Memorandum

Date: February 15, 2019

Re: Addendum to Grading Permit No. GP-18-00018 (Williams)

DRIVEWAY AND BRIDGE SITE PLAN  
DRAWING 10

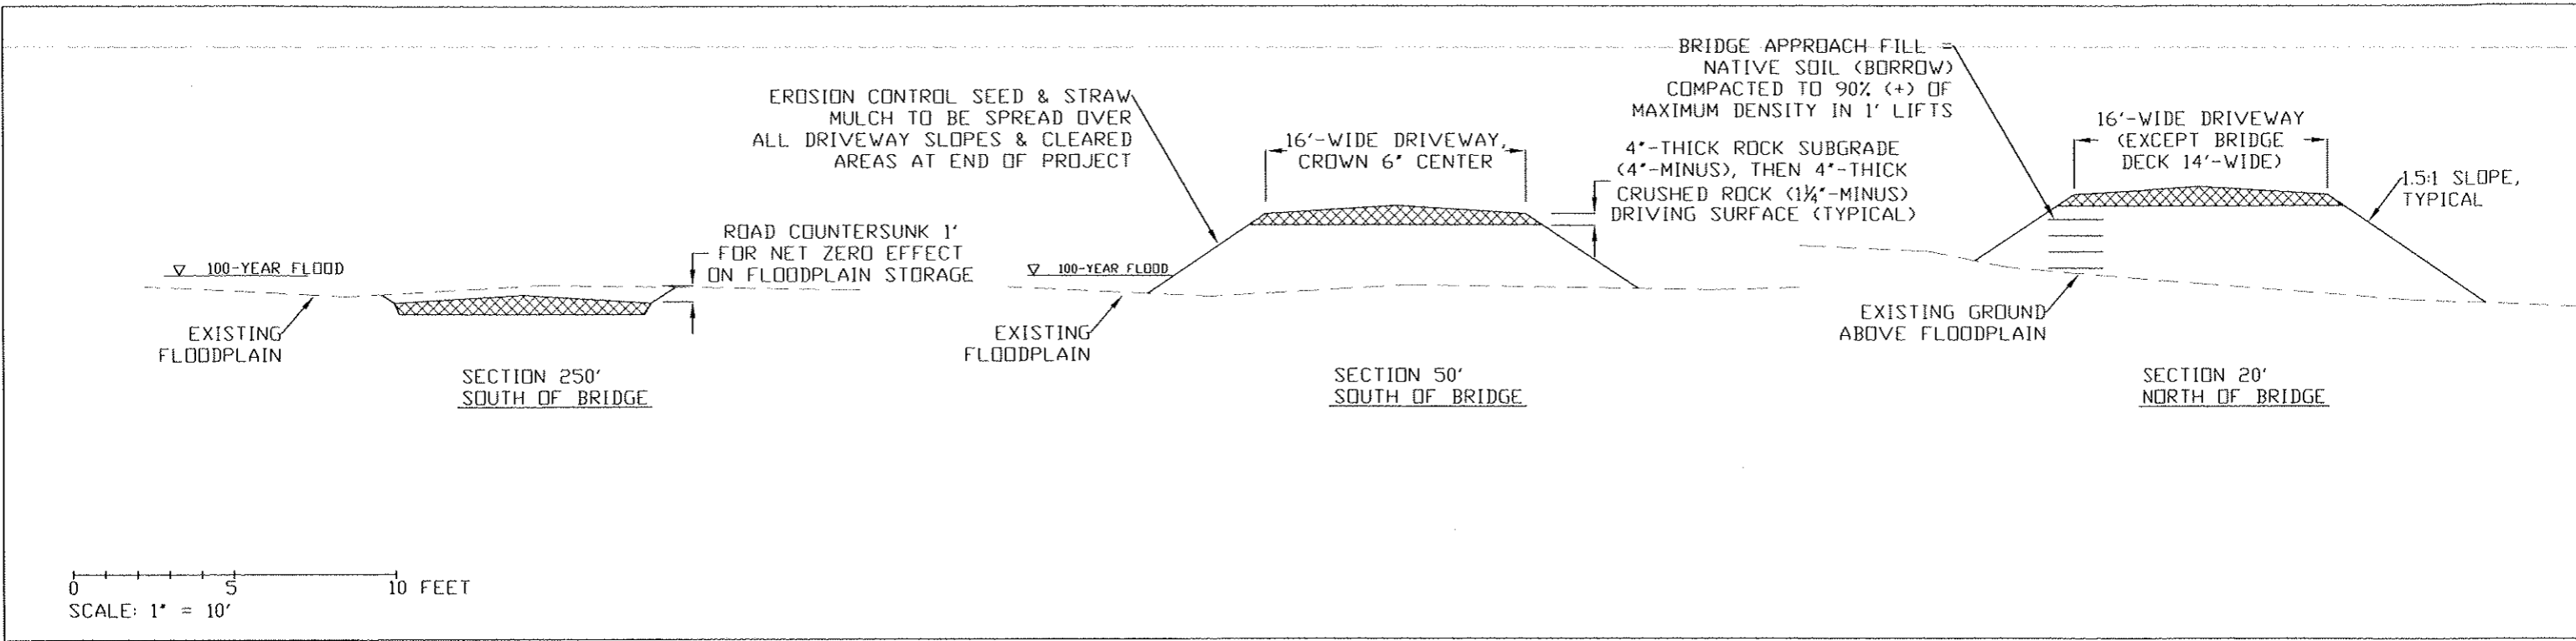
be needed for the approach on north side of bridge (Drawing 11); all fill north of the bridge will be above floodplain elevation (Drawings 10 and 11).

- ✓ The proposed loss of 130 CY floodplain water storage volume will be off-set by excavating a 220'-long driveway section to be about 1' lower than existing floodplain elevation (Drawings 10 and 11). The counter-sunk driveway (Drawing 11) will balance with proposed bridge approach fill for net zero change in floodplain water storage capacity.

I assumed that clearing and soil disturbance would occur to 4' outside the plan view area shown on Drawing 10 for the driveway, bridge approaches, and bridge. Total disturbed area for the project would be 12,900 ft² (0.30 acre). Disturbance of existing areas within the floodplain will be 9,700 ft² (0.22 acre) included within the total disturbed area. As noted on Drawing 11, all disturbed soils and new road slopes would be seeded, then straw mulch spread, after completion of the driveway construction project.
